PLANNING AMENDMENT

APPLICANT NAME AND ADDRESS MR. S. NECKER 143 BARTON ROAD WISBECH CAMBS	AGENT NAME AND ADDRESS PHA LTD 2 CHAPEL ROAD WISBECH CAMBS
Telephone:	Telephone: 01945 466966
SITE ADDRESS DETAILS REAR OF 29 STATION ROAD, TYDD GATE, NR. WISBECH	
CURRENT APPLICATION NO: This amendment cannot be considered unless the relevant reference is stated.	H 21/1136/23
Building Regulation reference relating to same development (if applicable)	N/A

SITE PLAN 1:500

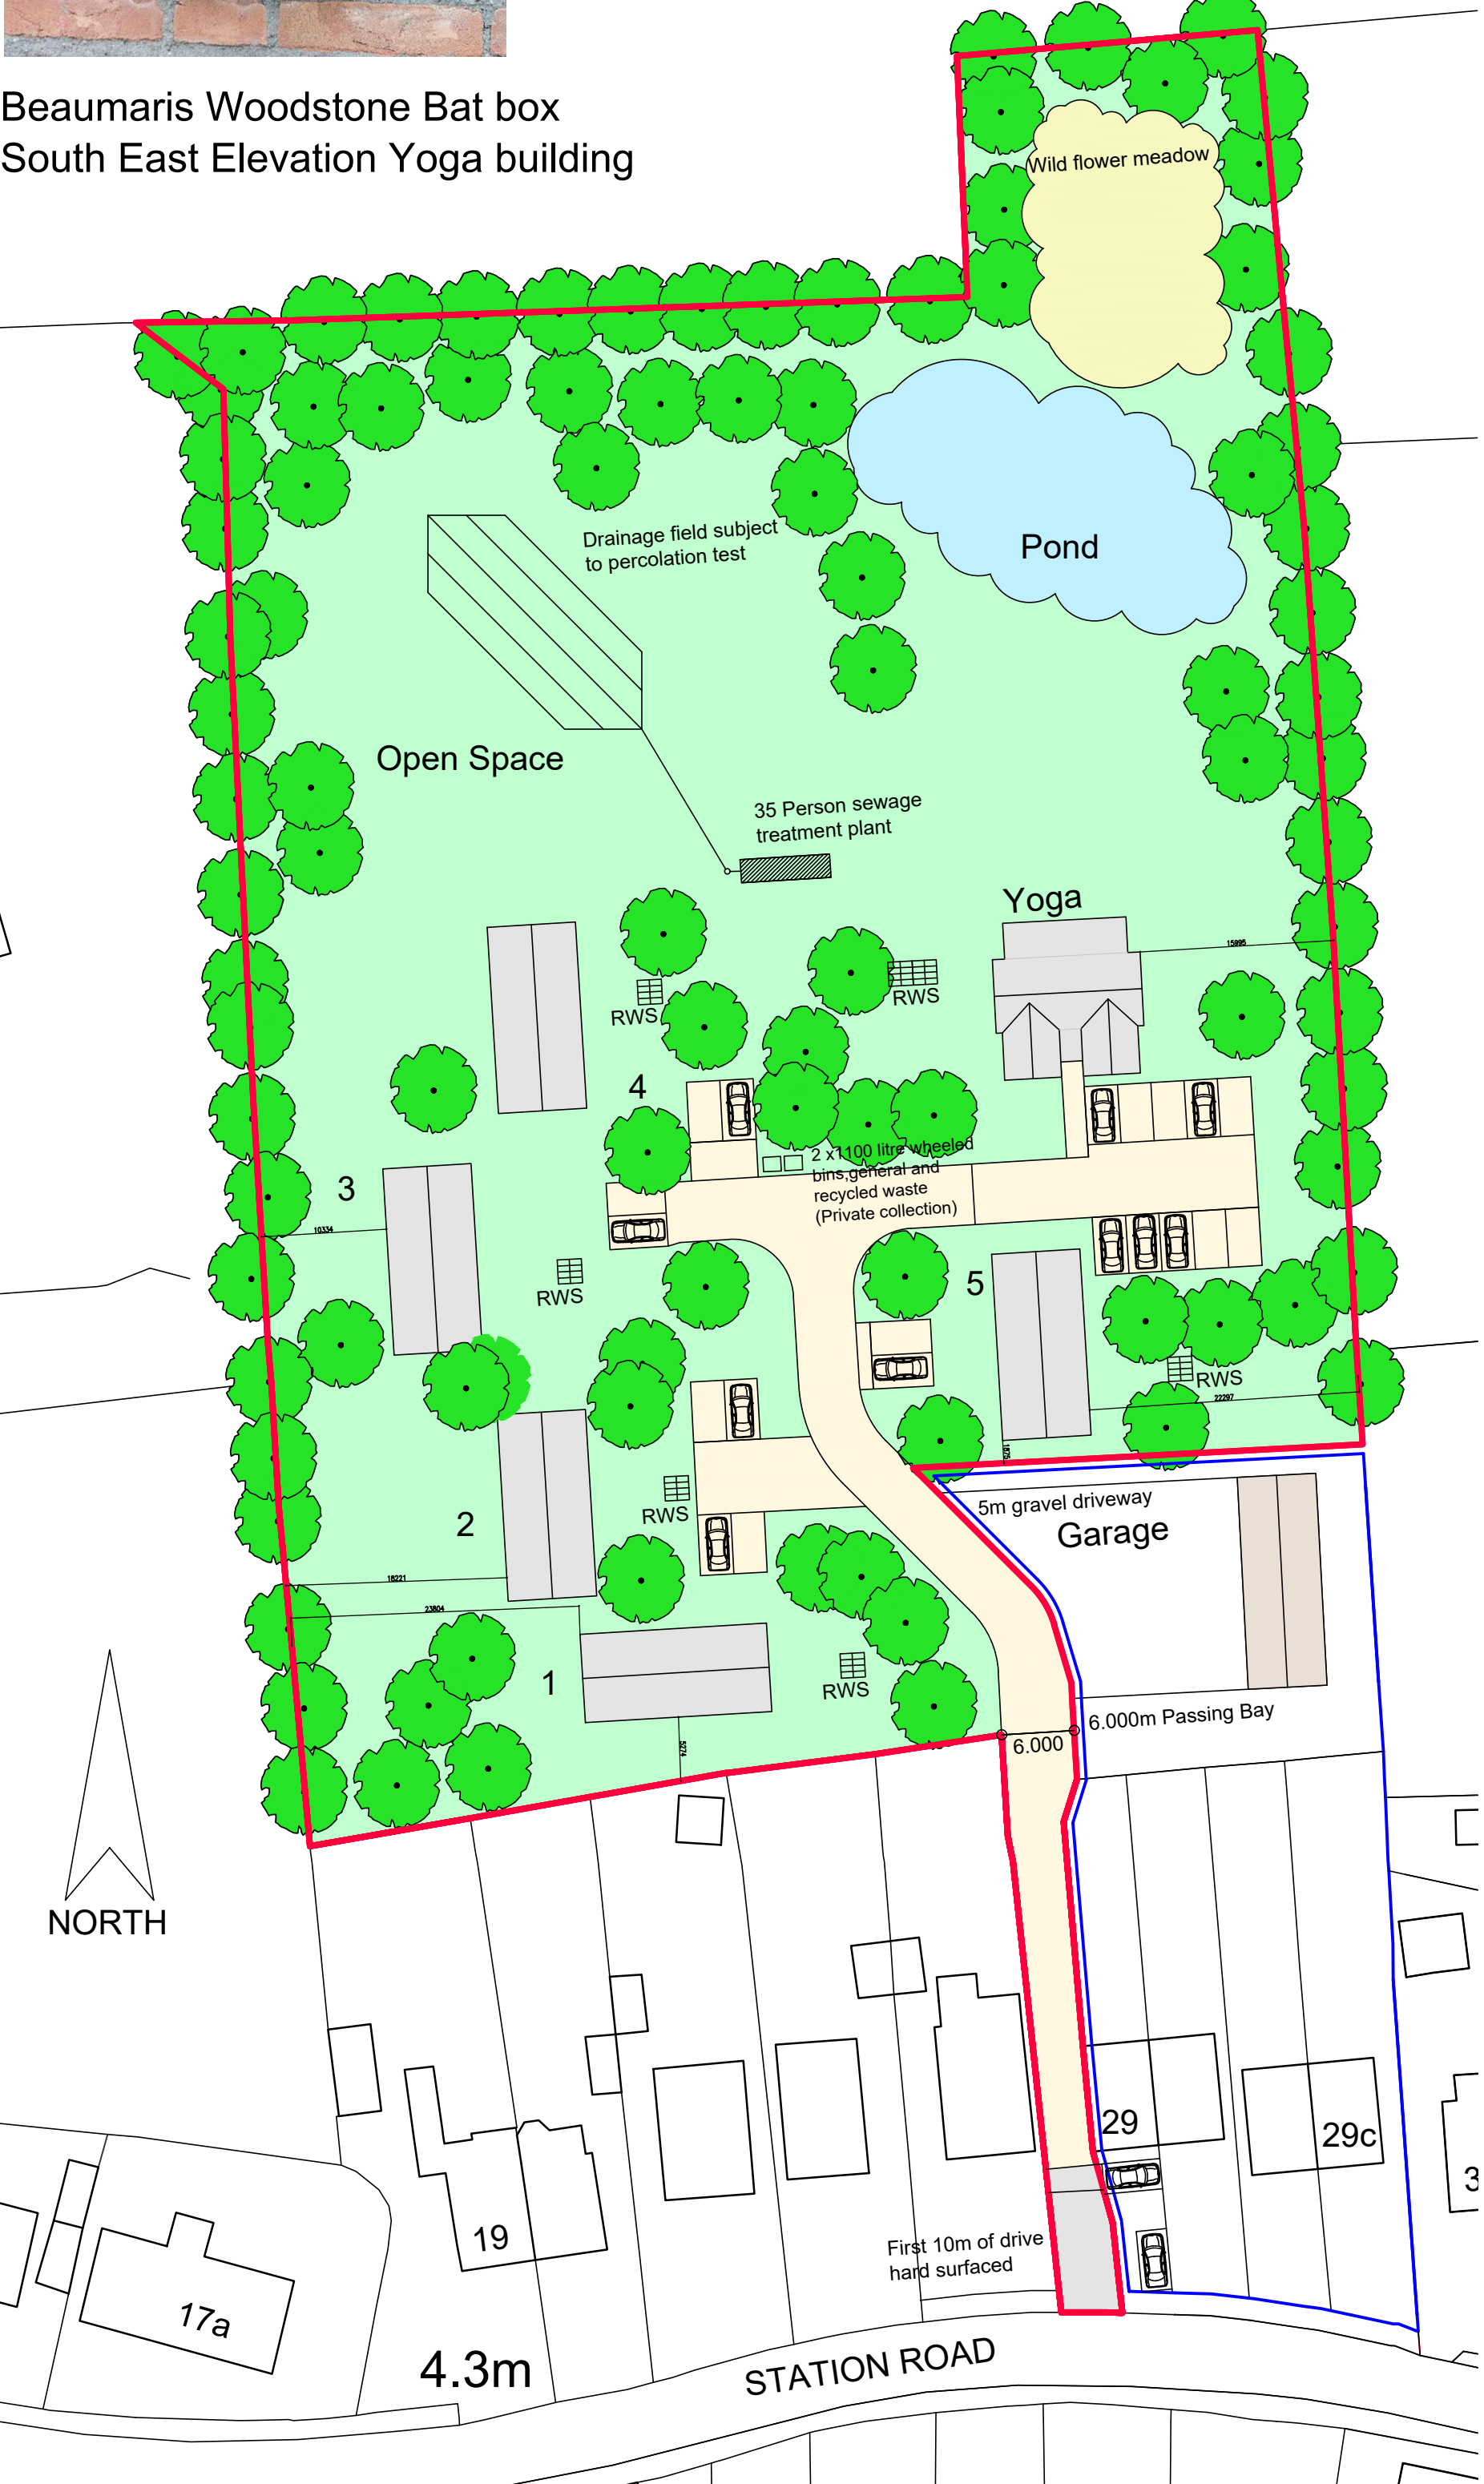
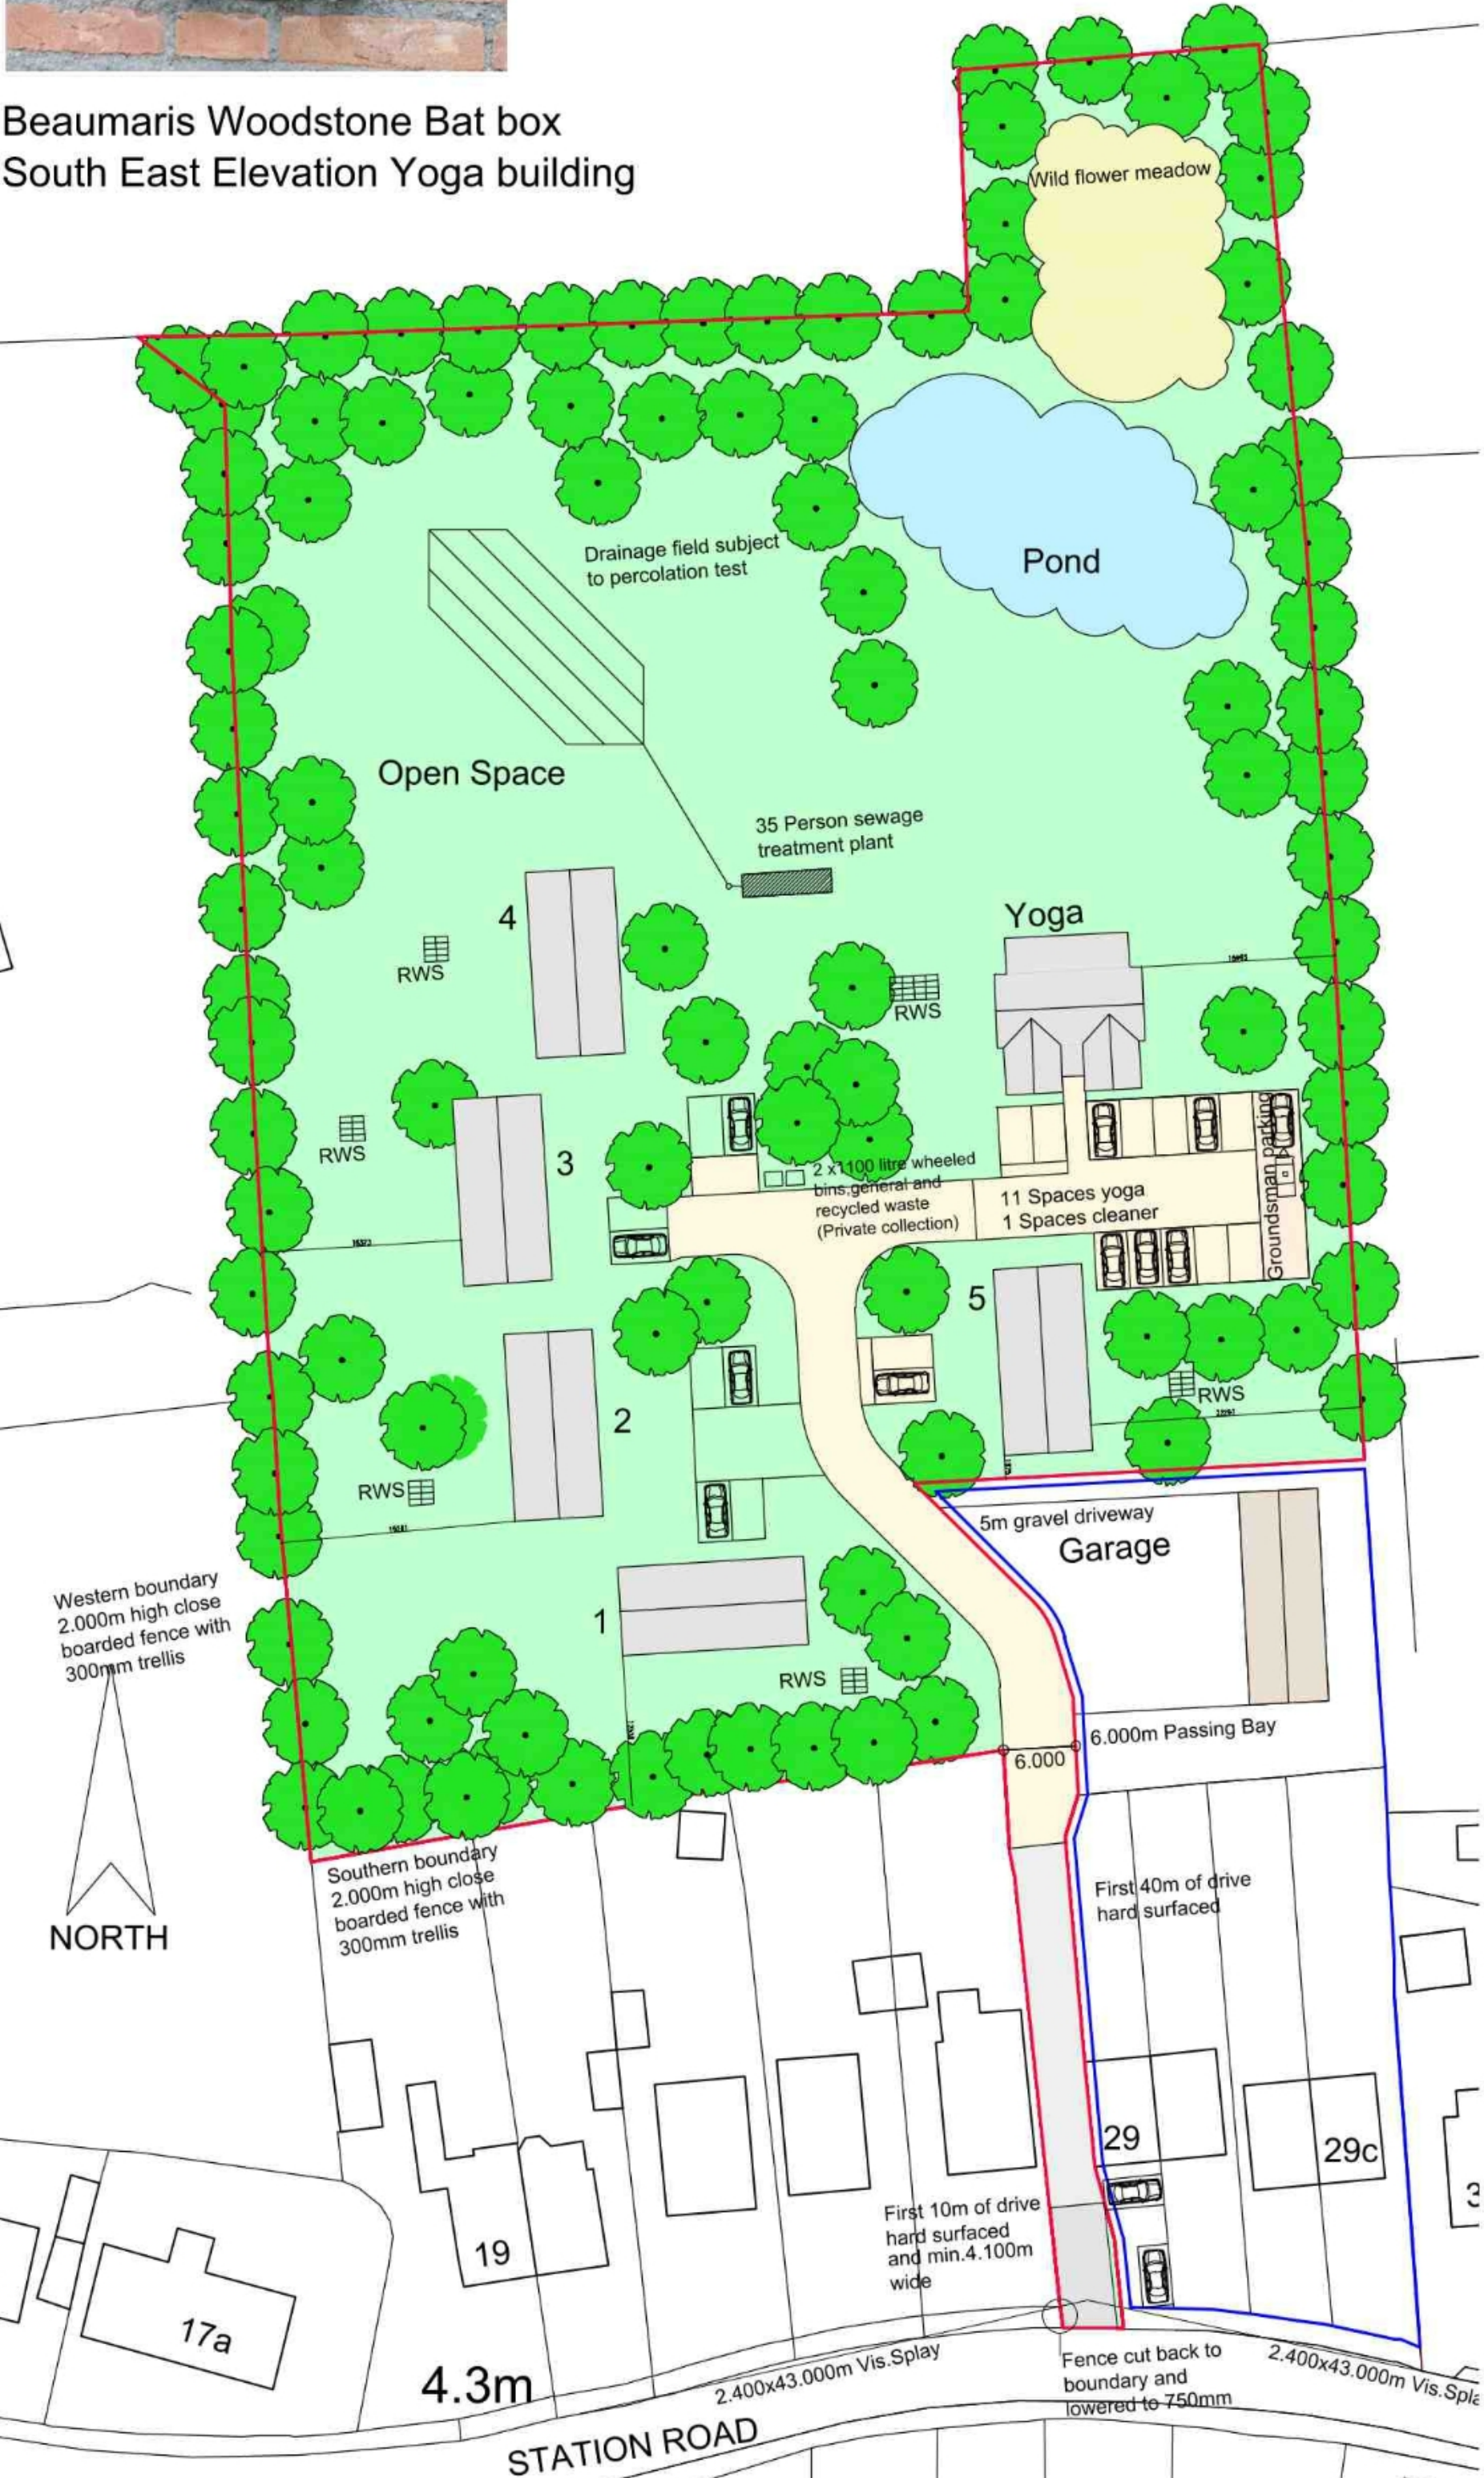
FULL DESCRIPTION OF DEVELOPMENT OF CURRENT APPLICATION THAT THIS AMENDMENT RELATES TO	
State details of amendments proposed. (Give a full detailed list of the changes; and also mark these clearly on the accompanying plans. Only the changes listed here will be considered)	WIDTH OF ACCESS ROADWAY ADDED TO DRAWING AS REQUESTED BY HIGHWAYS
State drawing numbers of the current submission	6830 PLO1A
Has this amendment been requested by the Council? (If so, state Officer dealing with the application)	YES/NO ☒ YES DAVID GEDNEY
Describe any part of the original development which is excluded by virtue of the amendment, and state any alteration to plot numbers	NONE
Has a similar amendment been submitted under Building Regulations? (If so, state Building Control Surveyor dealing with application)	YES/NO ☒ YES N/A
